Planning reference: 3/2025/0873

Location: Land at Springwood Drive, Whalley, BB7 9XL

Proposal: Construction of six detached dwellings with associated parking and landscaping at land off Springwood Drive

We refer to the letter from the Environment Agency dated 6th March 2026 in which the Environment Agency maintained their objection to the planning application, the reasons being given are below with our responses alongside.

**EXISTING SITE PLAN**

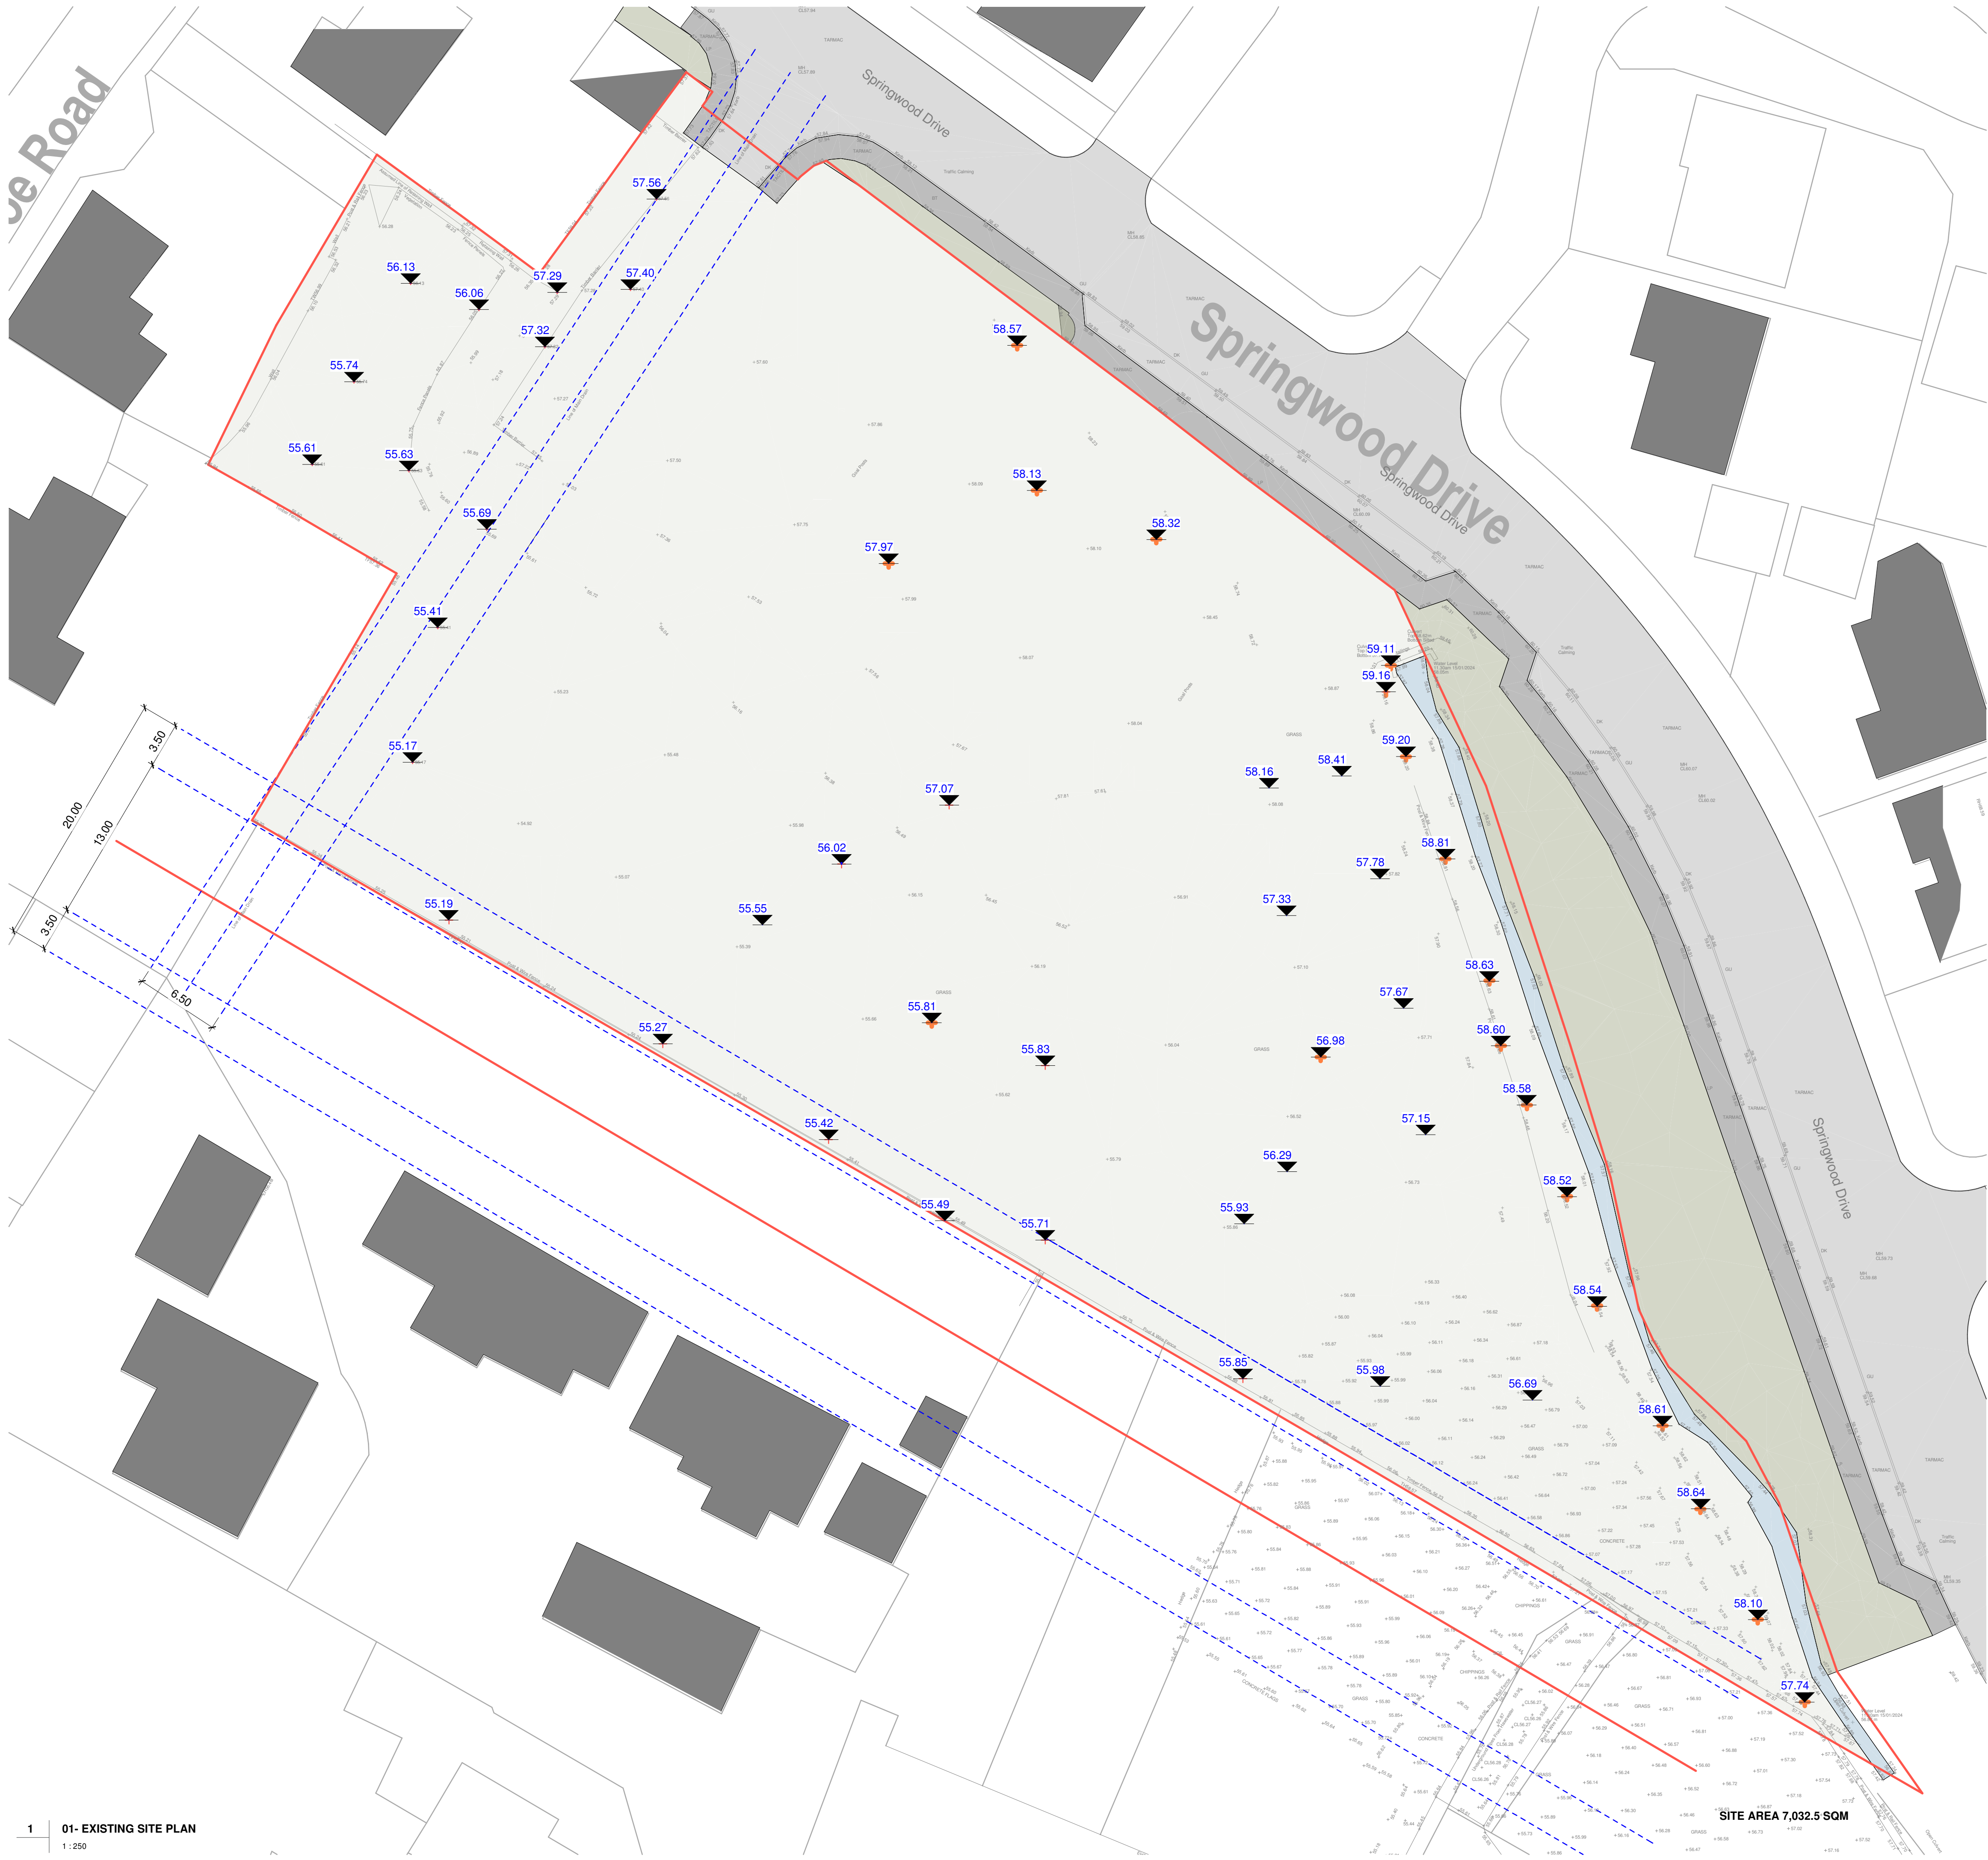
The FRA has not satisfactorily demonstrated that the site will not flood during the design flood (0.1% event used as a proxy for the 1% plus climate change event). The applicant must provide a sufficiently detailed / dense / concentrated / continuous survey which demonstrates adequately that there is no low spot which would cause flooding from Wiswell Brook. Consideration should especially be given to any riparian vegetation which could conceal low spots. We do not yet believe the applicant has demonstrated beyond reasonable doubt that there is no low spot in the right / western bank of Wiswell Brook, which would cause inundation to the site during a design flood.

Attention must especially be given to the stretch of bank where overtopping is shown to occur on the Whalley 2017 model, at the south-east of the site. The design flood level for Nodes References 931669 and 931620 is higher than the next respective downstream bank levels.

Furthermore, the applicant has not considered bank levels outside (i.e. south-east) of the red line boundary near 1d Node 931695 – the modelled 2d grid from our Whalley 2017 model shows a potential flowpath near this node, which could inundate the site in the 0.1% AEP event (which is being used as a 'proxy' for the 1% plus climate change design flood).

With regards to potential future floodplain encroachment north-west of the site (which is informed by the New National Model) – the FRA states “The route of this overland flow will not be obstructed by the proposed development, ground levels within this area of the site remaining existing”. The applicant should provide a site plan (with appropriate topographic information) overlayed with Flood Zones (namely Flood Zone 2 which is being used as a 'design flood proxy' as demonstration.

Response: We have produced a site specific flood risk assessment using a detailed topographical survey of the site. LiDAR information has not been used. As requested, we have carried out sufficiently detailed / dense / concentrated / continuous additional survey work to the stretch of the western bank of the Wiswell Brook where overtopping is shown to occur on the Whalley 2017 model at the south-east of the site.

In order for an accurate survey to be carried out the vegetation was cut back along the bank of the Wiswell Brook prior to the survey. The information from the survey demonstrates that there is no low spot within the western bank which would cause flooding from the Wiswell Brook into the development site. As such the water within the Wiswell Brook stays within the channel and does not overtop the western bank into the development site for the 0.1% AEP event, which has always been the situation.

As such the Flood Zone 3 area within the site close to and along the southern boundary of the site before flowing south should be identified as lying within Flood Zone 1. A copy of the additional survey is included with this letter.

With regards to potential future floodplain encroachment north-west of the site, the site plan, with appropriate topographic information, has been overlayed with the Flood Zone 2 boundary. The site plan demonstrates that the route of the overland flow will not be impeded by the proposed development.
